20 March 2019

**Re: State Significant Development  
Application (SSD8660)  
Kariong Sand & Soil Supplies Facility**  
**Property: LOT: 4 DP: 227279 No. 90 Gindurra Road SOMERSBY**

Client		KARIONG SAND AND SOIL SUPPLIES			
Project		SAND, SOIL & BUILDING MATERIALS RECYCLING FACILITY.		Status	
90 GINDURRA ROAD		SOMERSBY		PRELIMINARY	
Title		CONCEPT STORMWATER MANAGEMENT PLAN		NOT TO BE USED FOR CONSTRUCTION PURPOSES	
Drawing Number		80518002-CI-115		Revision	
				6

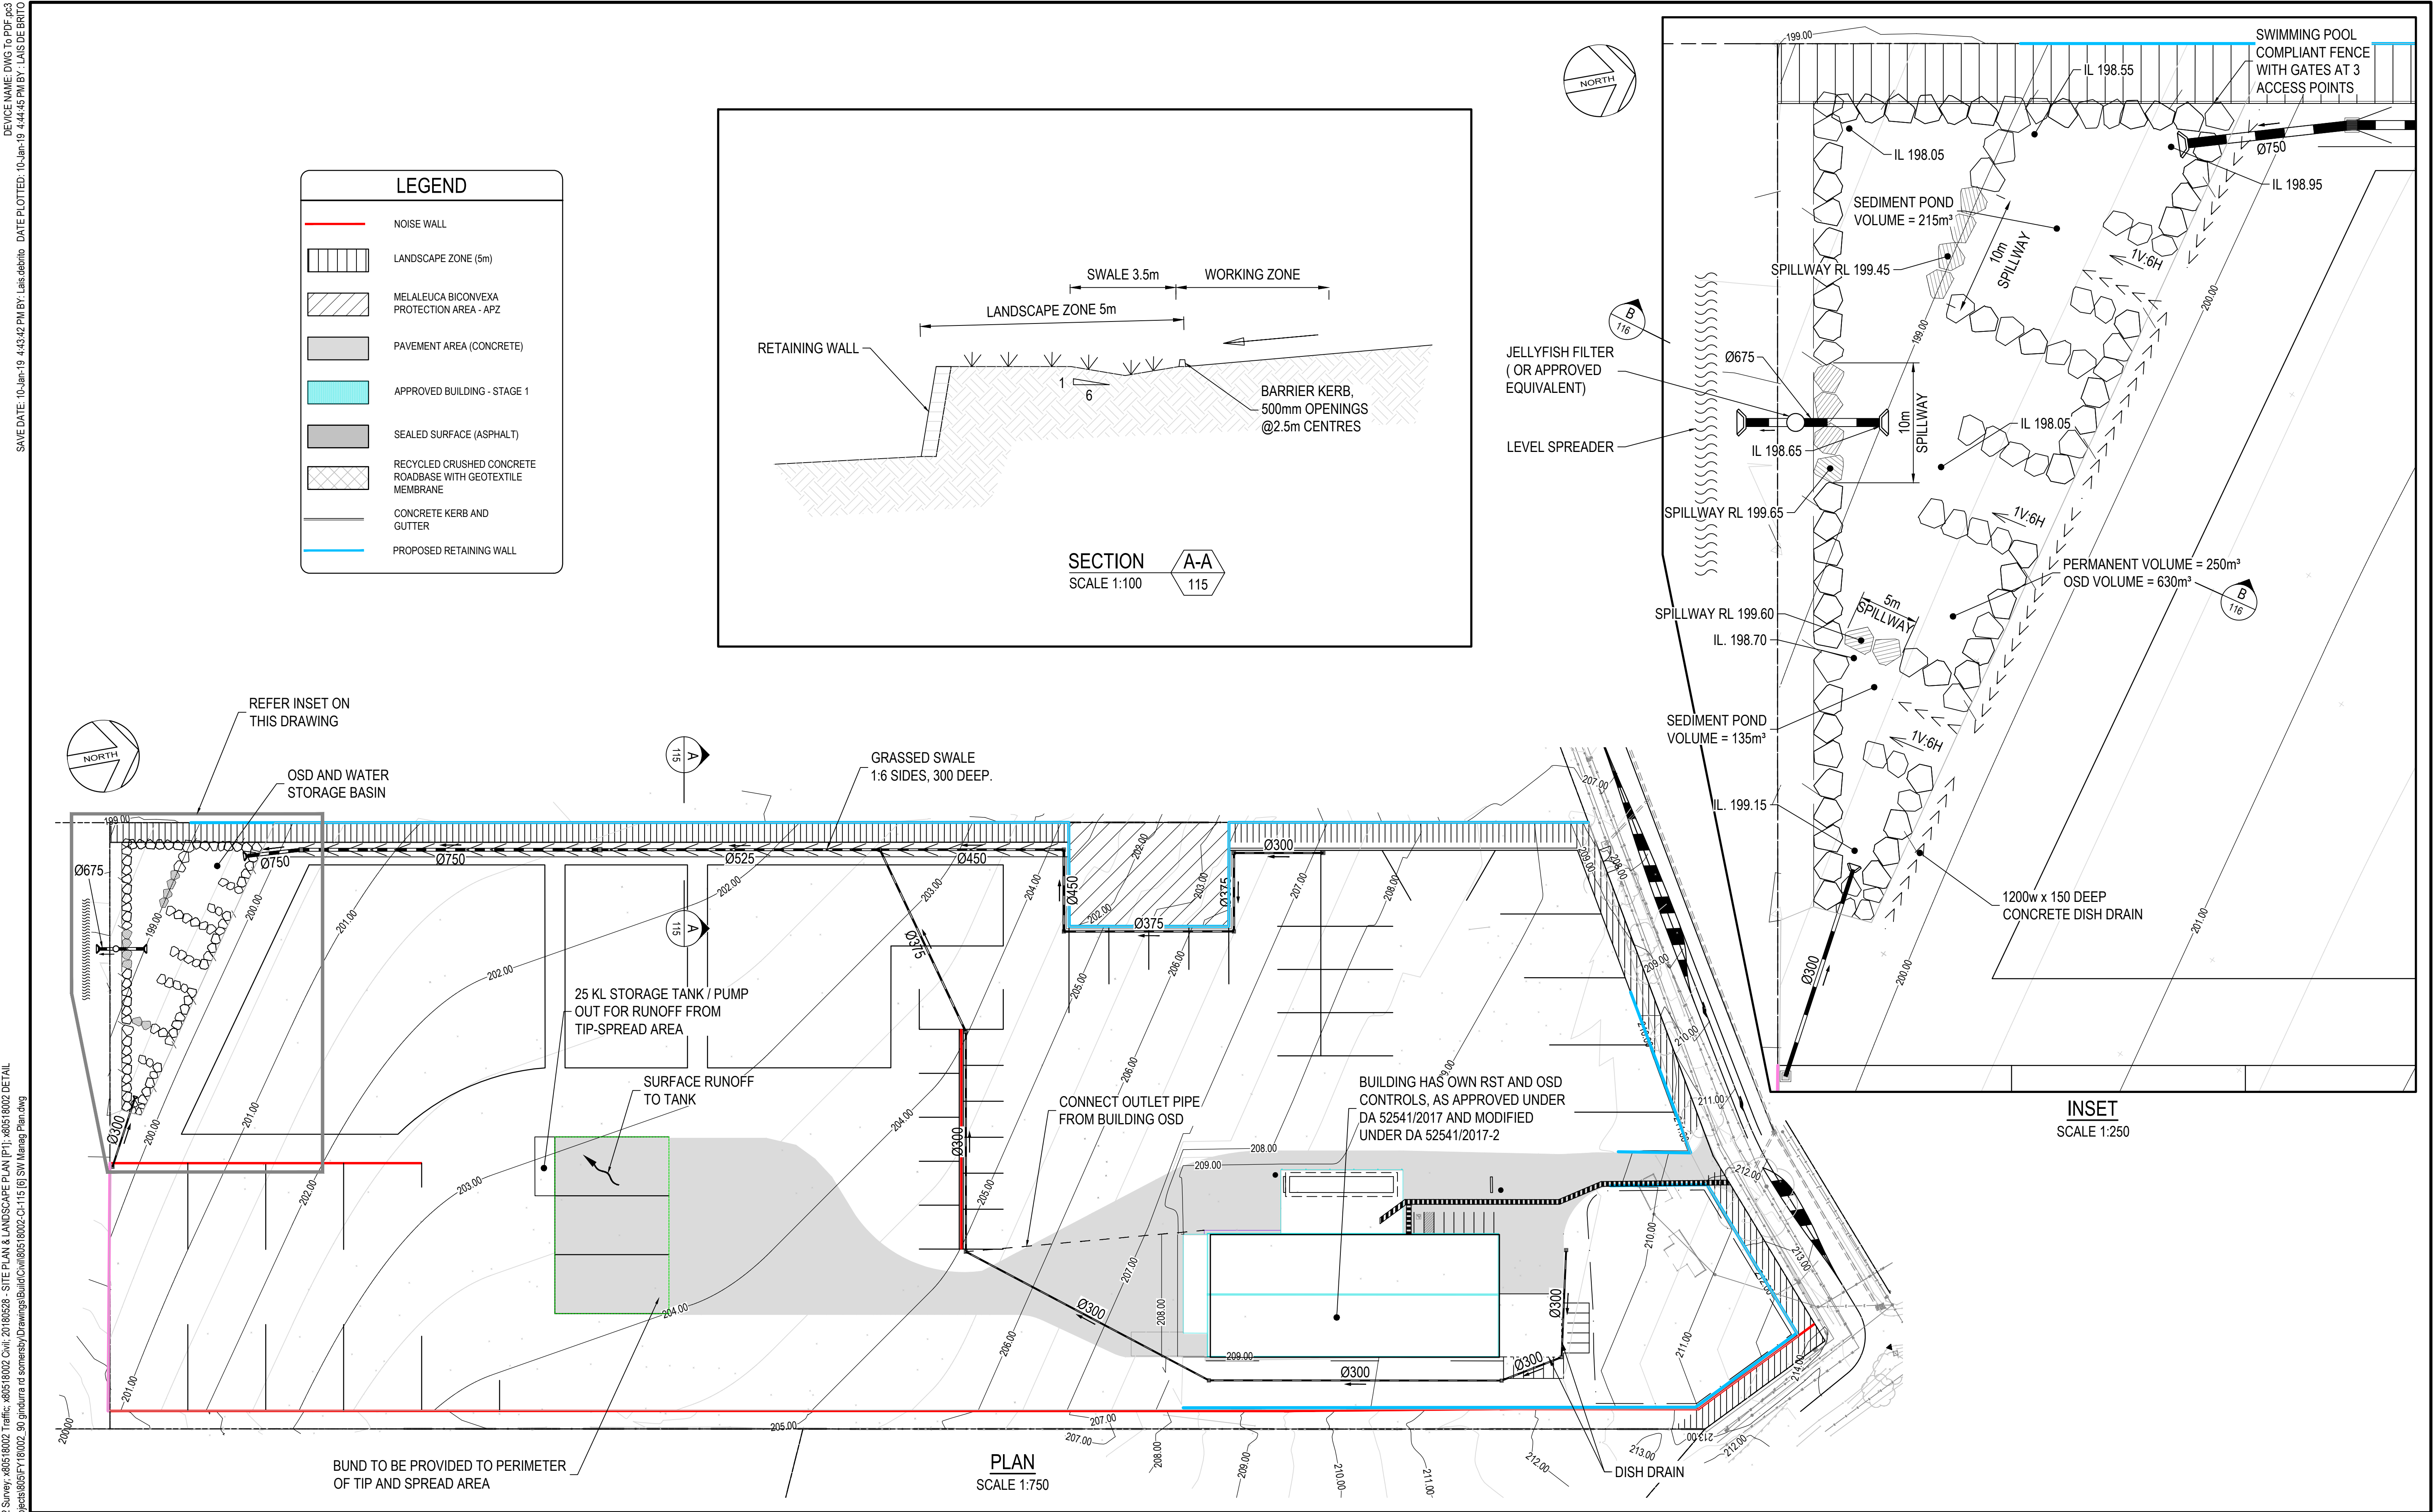
A concept stormwater management plan prepared by Cardno (NSW/ACT) Pty Ltd was also submitted which details the concepts for the abovementioned stormwater management associated with the associated abovementioned WCMP. These details appear to be satisfactory for the purposes of review of the stormwater management for this development proposal.
